Your Ref: OWPC23683
Our Ref: EP/74/19/HH 18-06-2019
Please ask for:
Zac Denton

Hip to barn hip extension, north dormer extension, single storey rear extension.
2 Hillview Crescent East Preston

Proposed Elevations

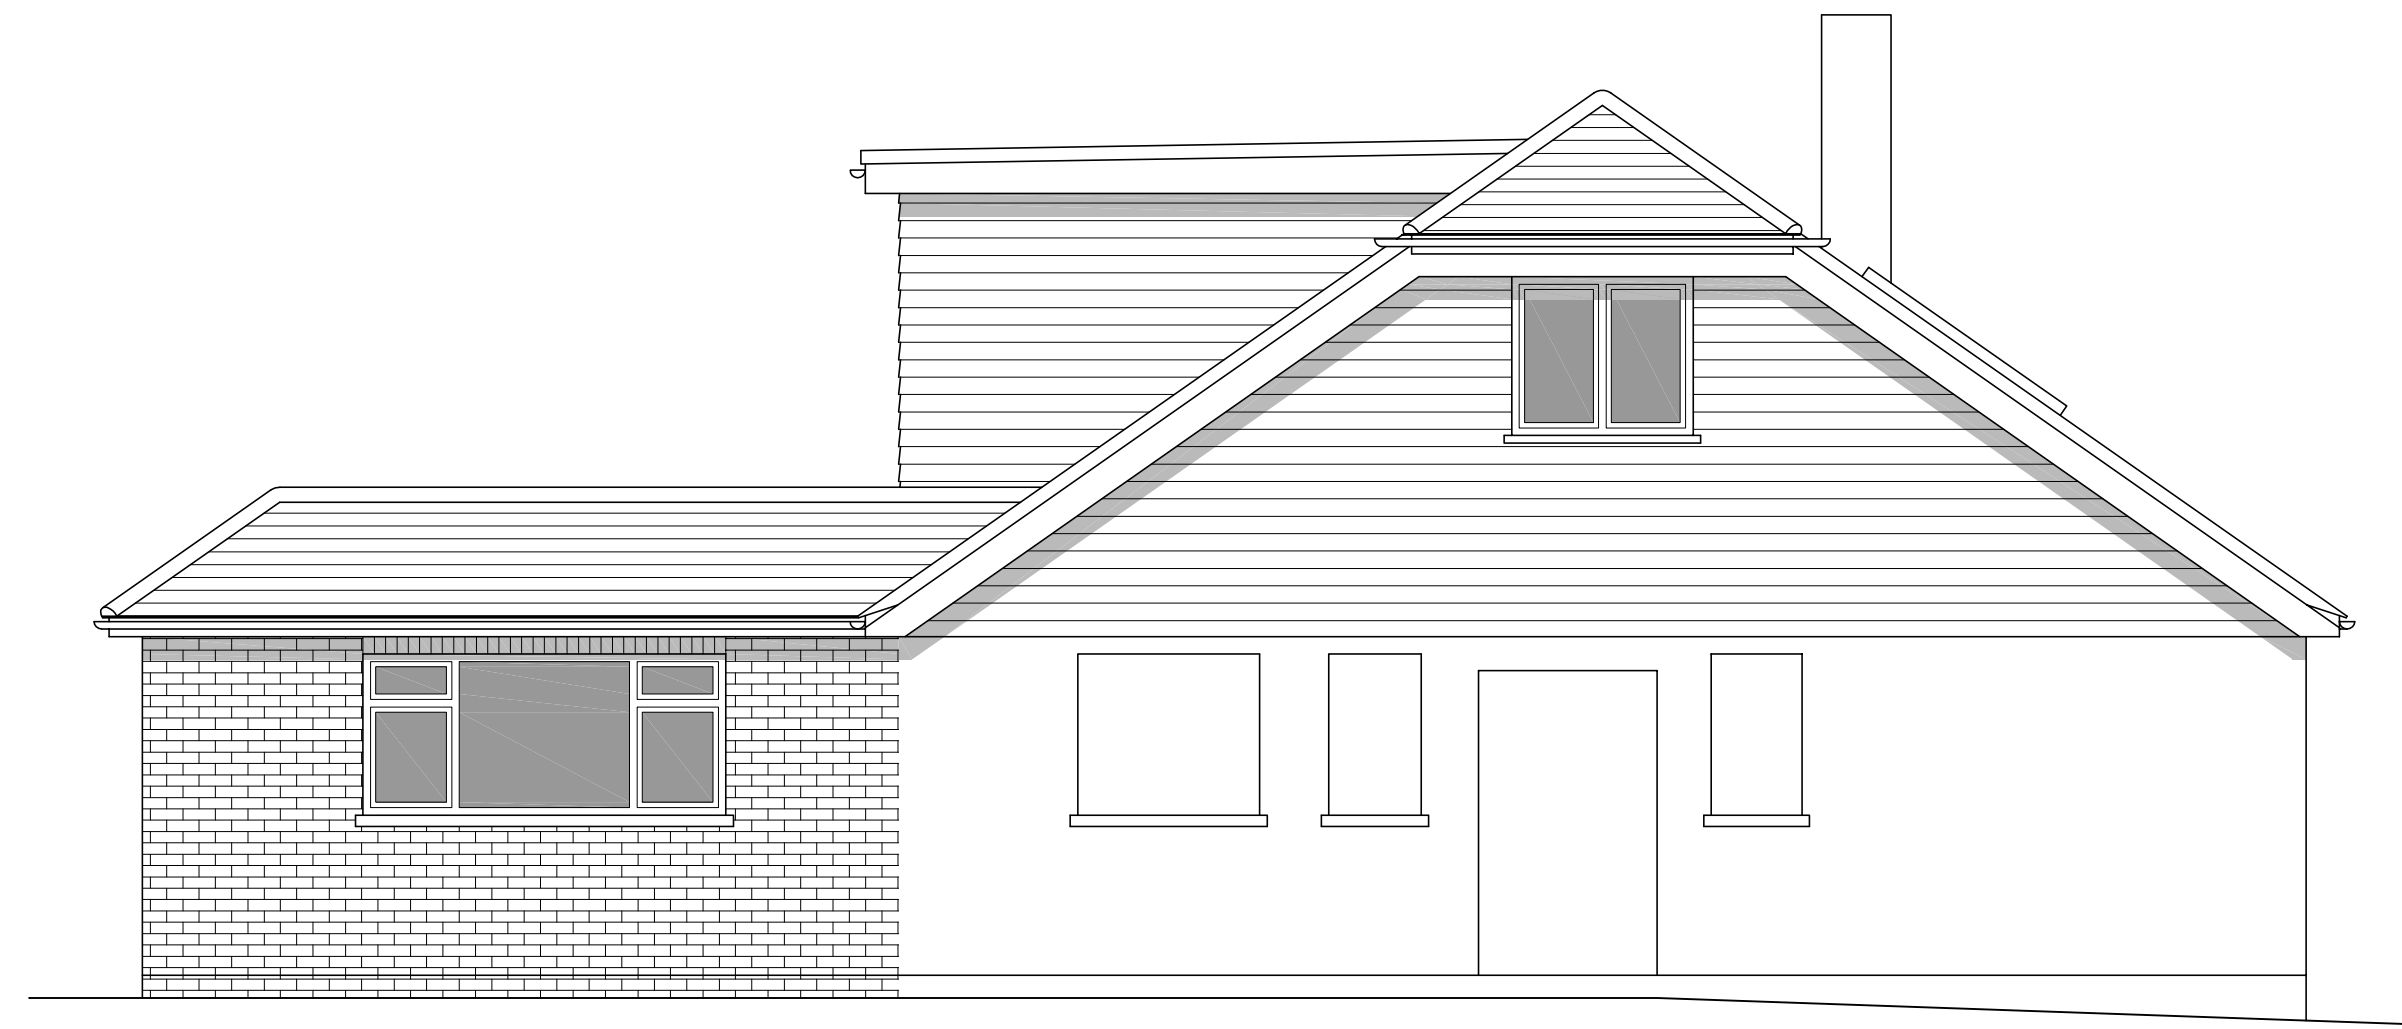
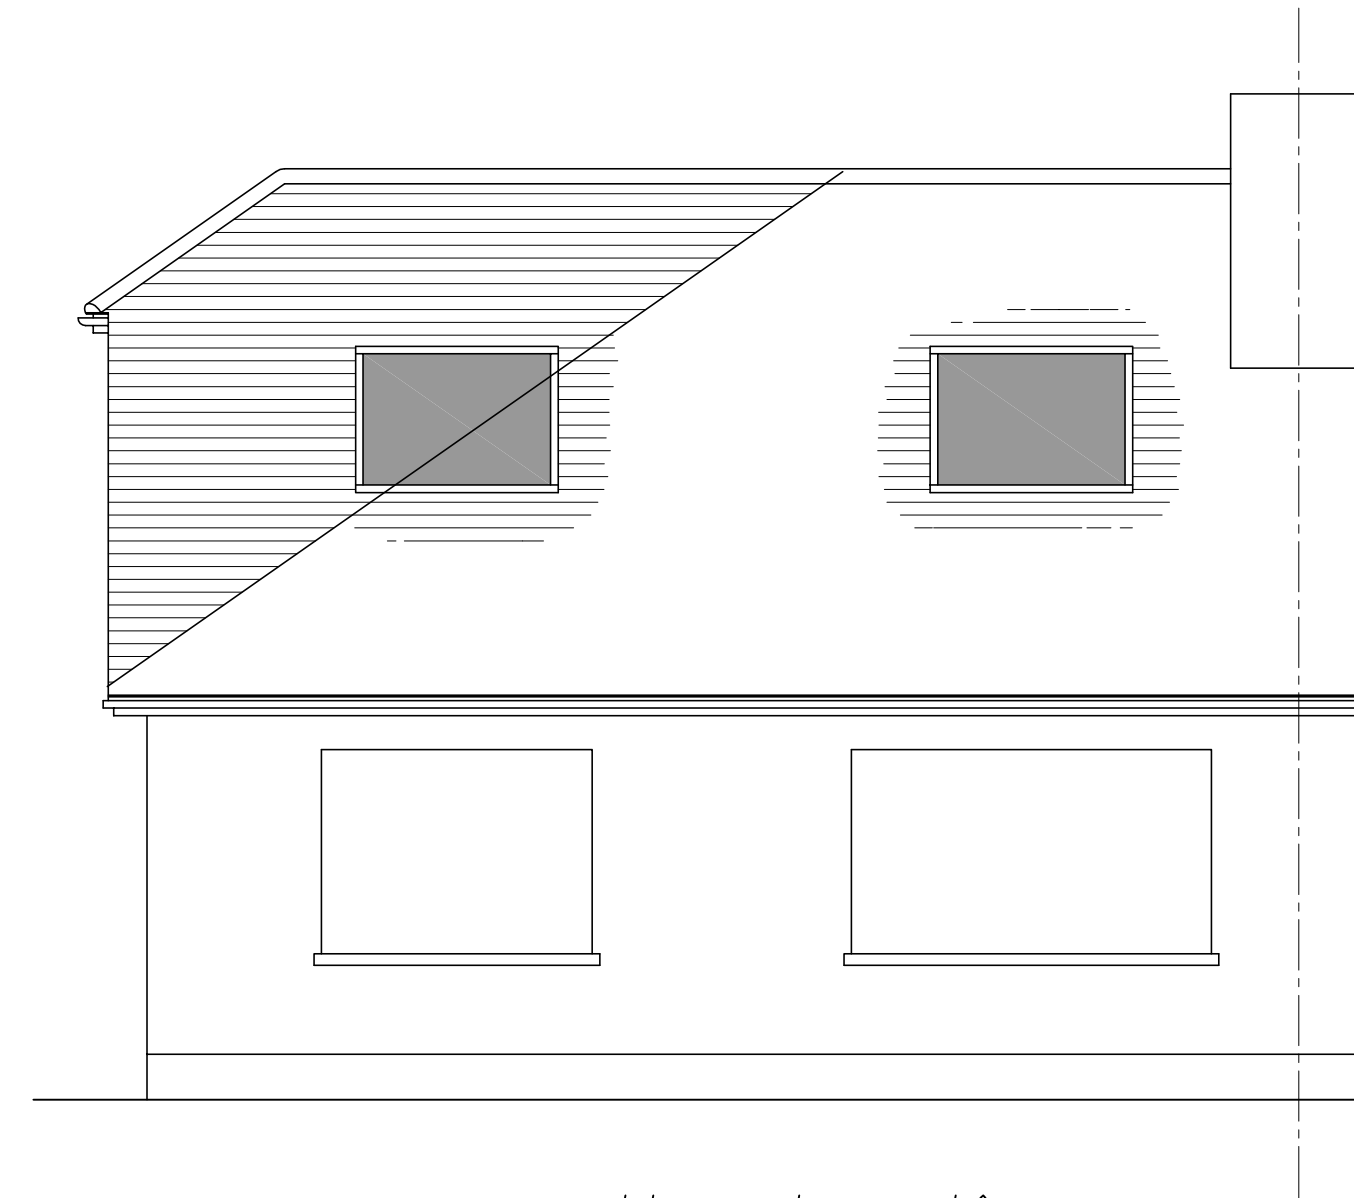
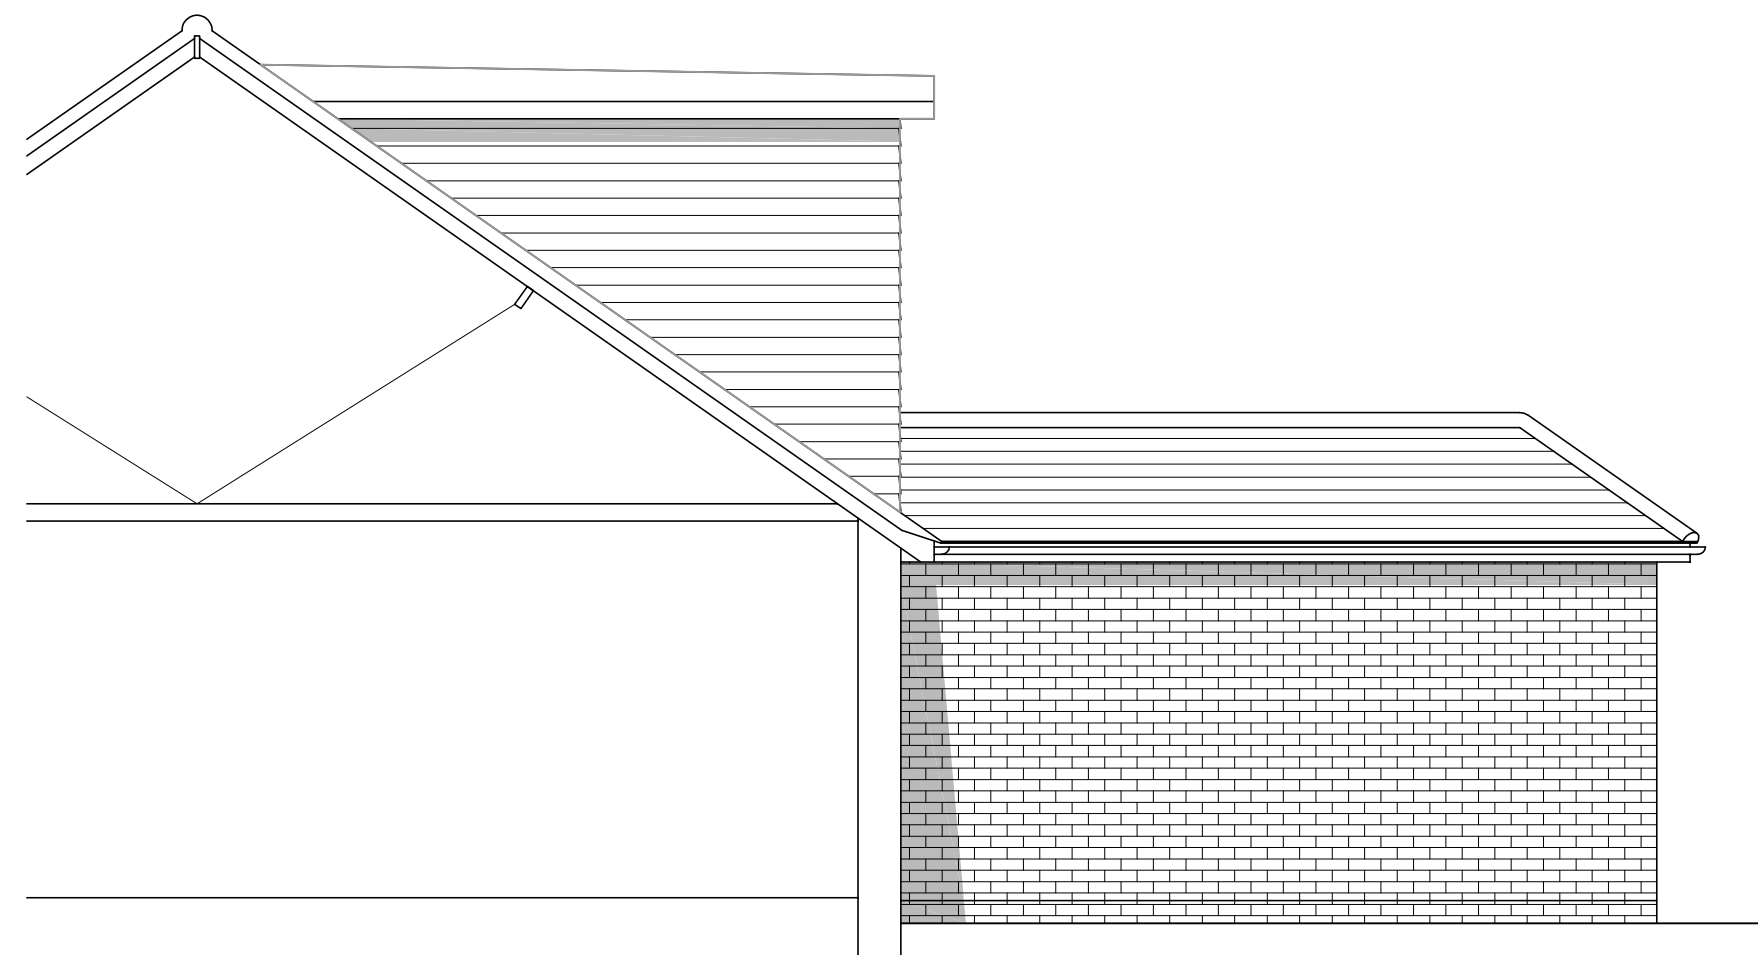
This original application was refused last year. We are now objecting this year on the following bases: it will adversely affect the aesthetics of the neighbourhood and the entrance to Hillview Crescent, and cause at least 3 back gardens of opposite and adjacent dwellings to be over looked.

The current extension at 4 Chiltern Close, which is sited in the original supporting documentation, is a barn-end conversion, without a dormer, and was explicitly designed to ensure all neighbours were not overlooked and that windows that were facing any property were frosted (this property is also situated within a row of other semi detached properties about 50 metres into Chiltern Close). Our main opposition to these plans for 2 Hillview Crescent is the huge dormer that is to be built on the rear of the property. It will not only spoil the building profile of bungalows in Orchard Road and Hillview Crescent, but also provide viewable access to the gardens behind and to the right. We currently enjoy spending significant time in our garden which are both private and without visual intrusion, this being the reason we bought the bungalow. If the current plans are approved, this dormer extension will remove these. We are also concerned that an extension of this nature being approved will set a precedent for other properties to build extensions of the same size.

It is hoped that those members of the planning committee who are involved in the assessment of this re-application will understand our outrage that this dormer extension is
